13th August 2017

WA/44/17/OUT: Outline application with some matters reserved for up to 175 dwellings, new vehicular access, together with associated car parking, landscaping & community facilities to include allotments, play space & community orchard. This application is a Departure from the Development Plan & may affect the character & appearance of the Walberton Village Conservation Area. Land East of Tye Lane, Walberton

This is the formal response of the Sussex branch of the Campaign to Protect Rural England (CPRE Sussex) to the above application. CPRE Sussex works to promote the beauty, tranquillity and diversity of the Sussex countryside by encouraging the sustainable use of land and other natural resources in town and country. We encourage appropriate and sustainable land use, farming, woodland and biodiversity policies and practice to improve the well-being of rural communities.

WALBERTON
LANDSCAPE AND VISUAL IMPACT
ASSESSMENT
VIEWPOINT 3
WA - 006

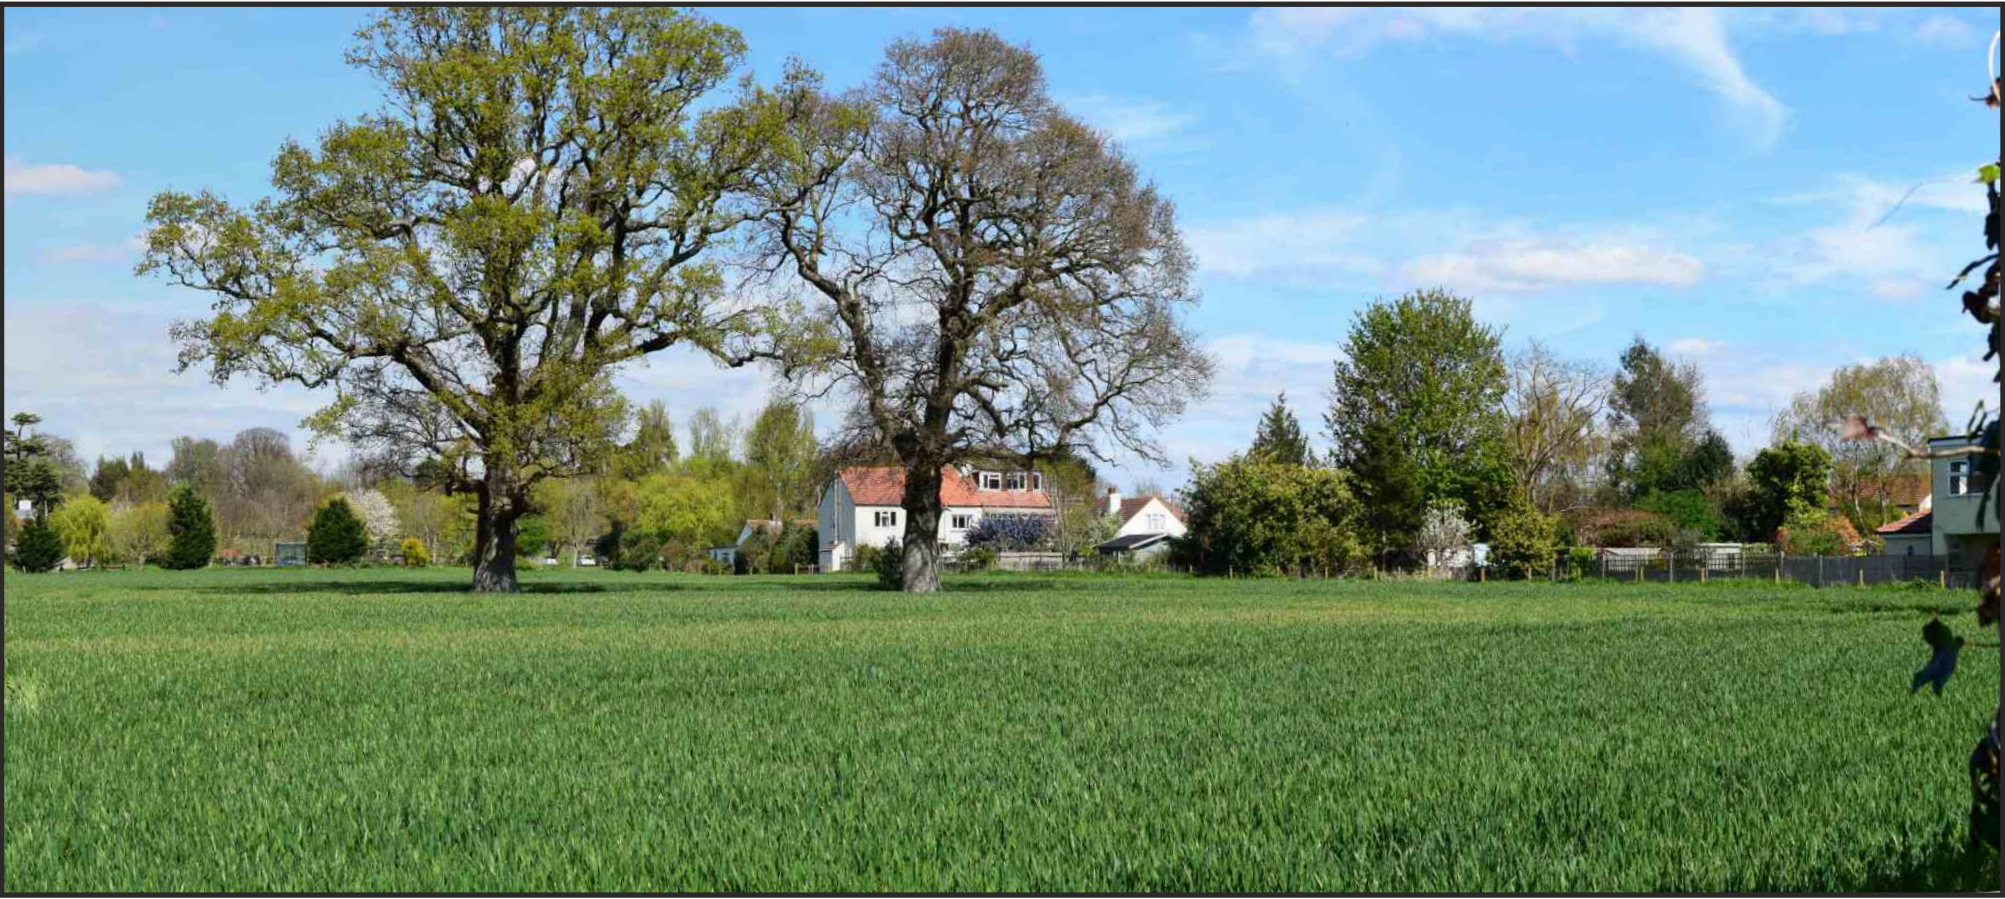
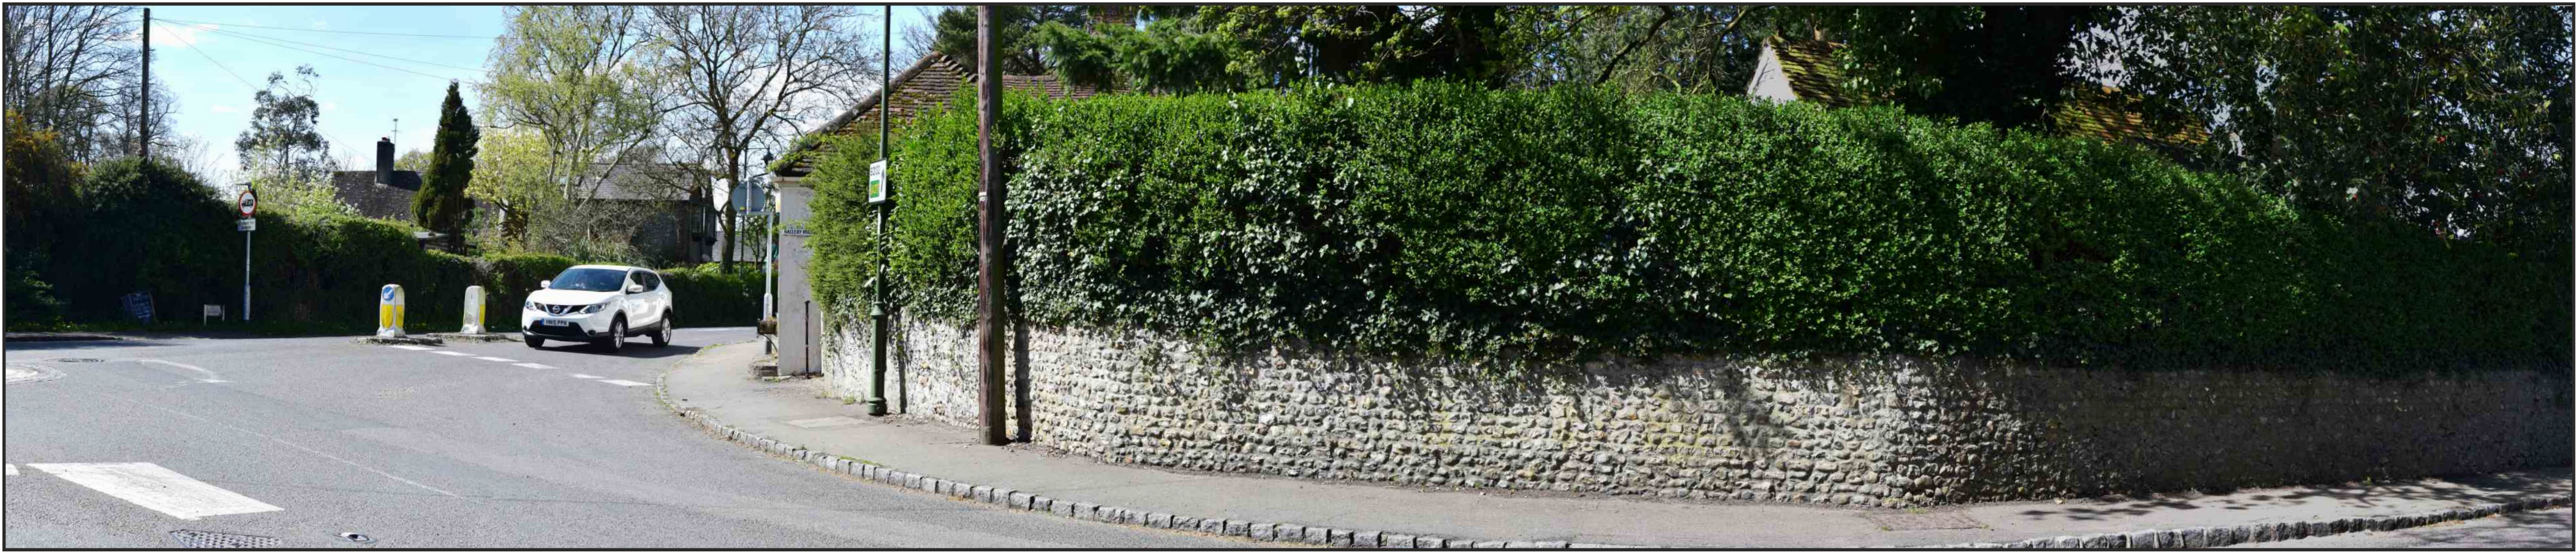
As regards visual impact, the site is apparent from nearby views, including from the public footpath that runs from the centre of the village along the southern boundary of the eastern part of the site (Public Footpath 333), as clearly demonstrated by the photographs from viewpoints 3A and 3B in the . Landscape and Visual Impact Assessment (LVIA) submitted with the application. The LVIA notes that from (at least) two viewpoints, the proposed development would result in "significant adverse effects" immediately after construction (5.5), which effectively could mean until 8-12 years after construction when the landscaping would reach semi-maturity (5.2).
